CITY OF ALBUQUERQUE

March 6, 2017

RE: La Cumbre Cold Storage Building
Grading and Drainage Plan
Engineer's Stamp Date 2-13-2017 (File: G16D103)

GRADING AND DRAINAGE PLAN

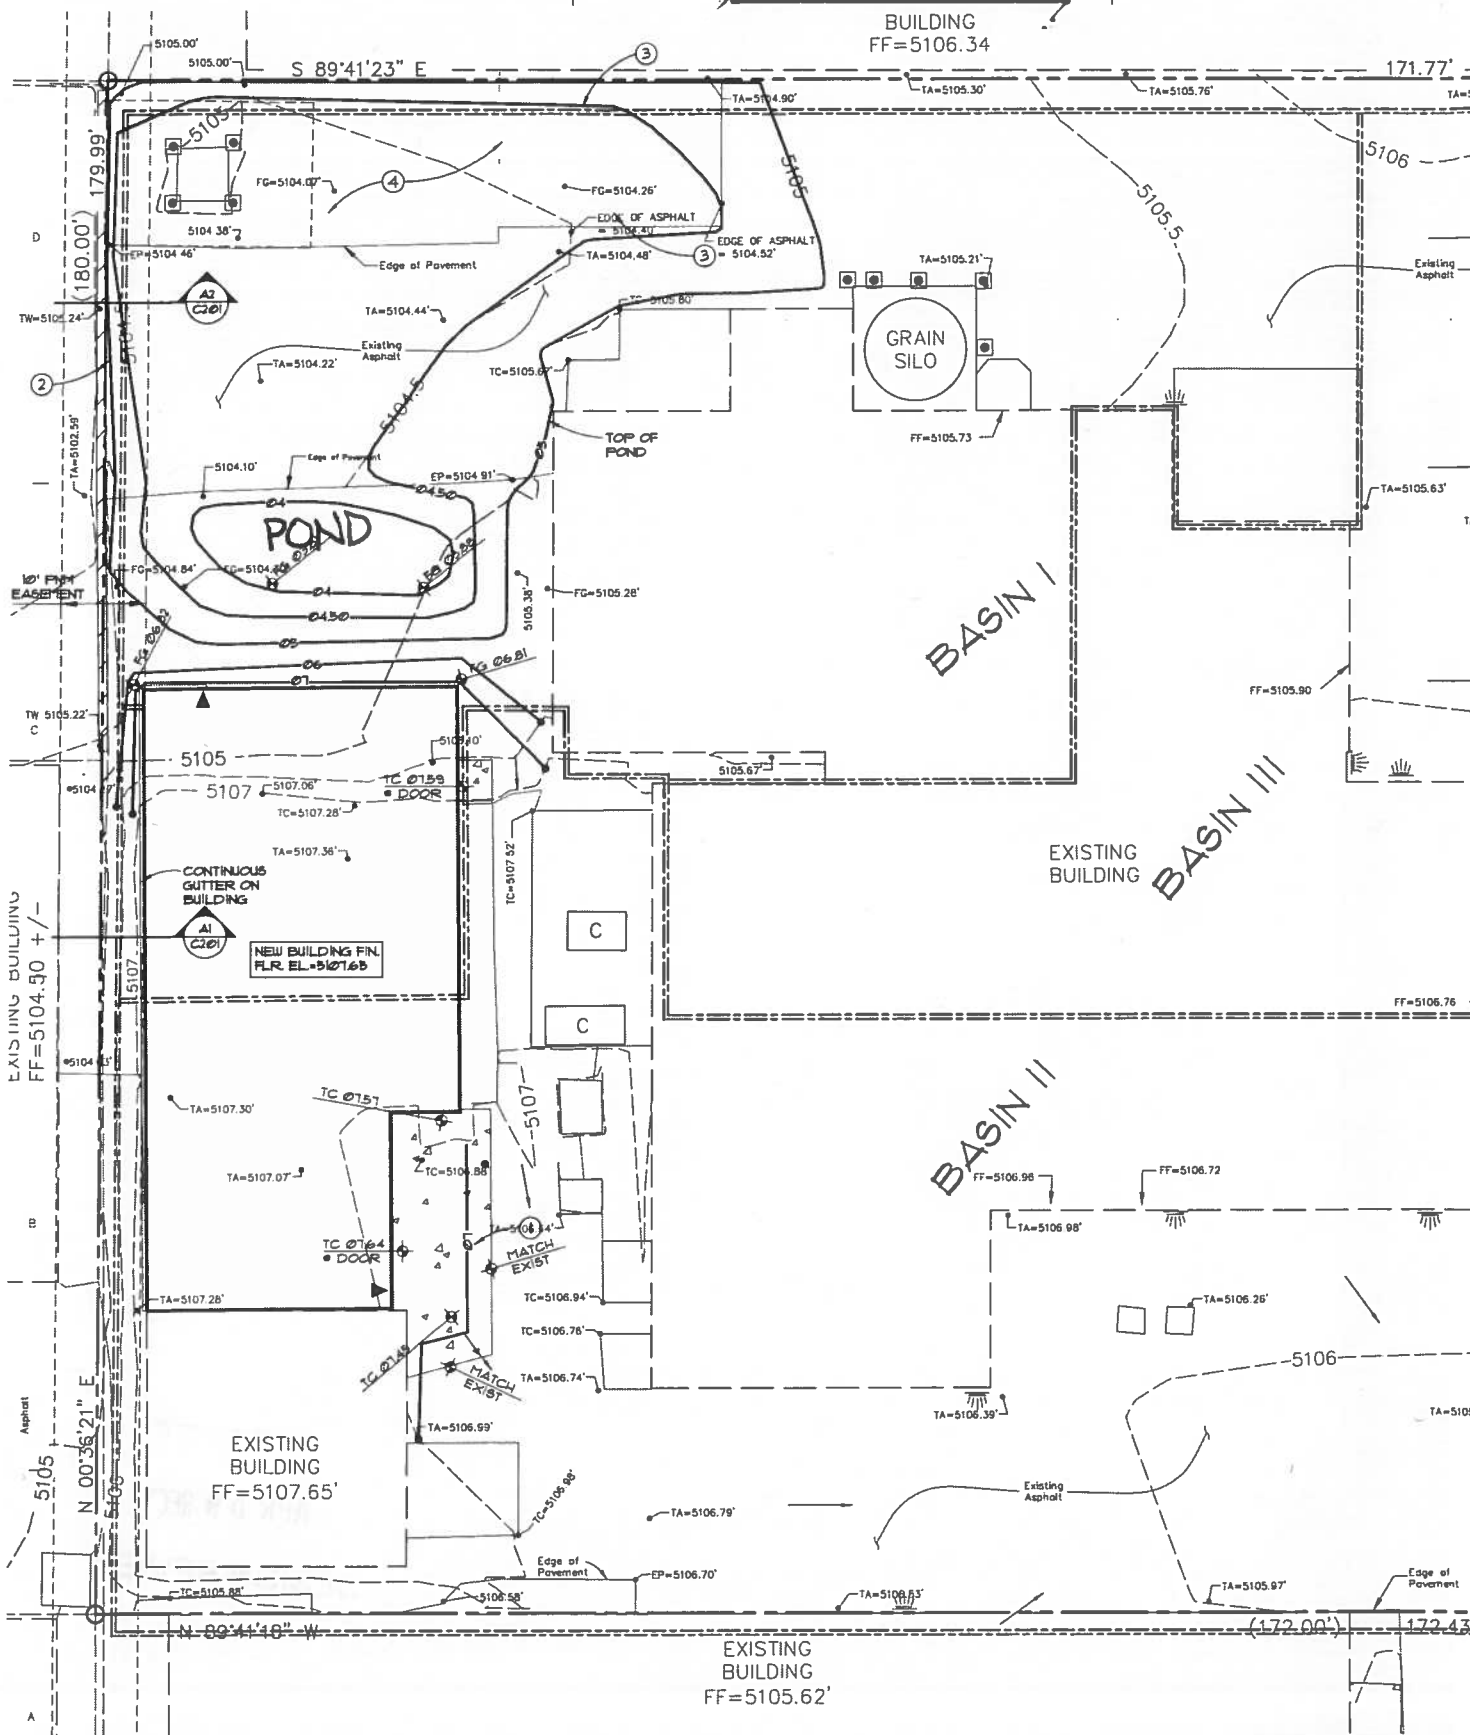
1. Provide offsite flow narrative.
2. It appears the north portion of the site will drain to the northwest end of the site and will not outfall to the Girard Ave. NE. and the west side the new building it drains to the southwest corner.
3. An updated Traffic Circulation Layout will be required. Is there a revocable permit for the use of Right of Way for parking?
4. Grading plan must reflect any changes to the parking spaces.
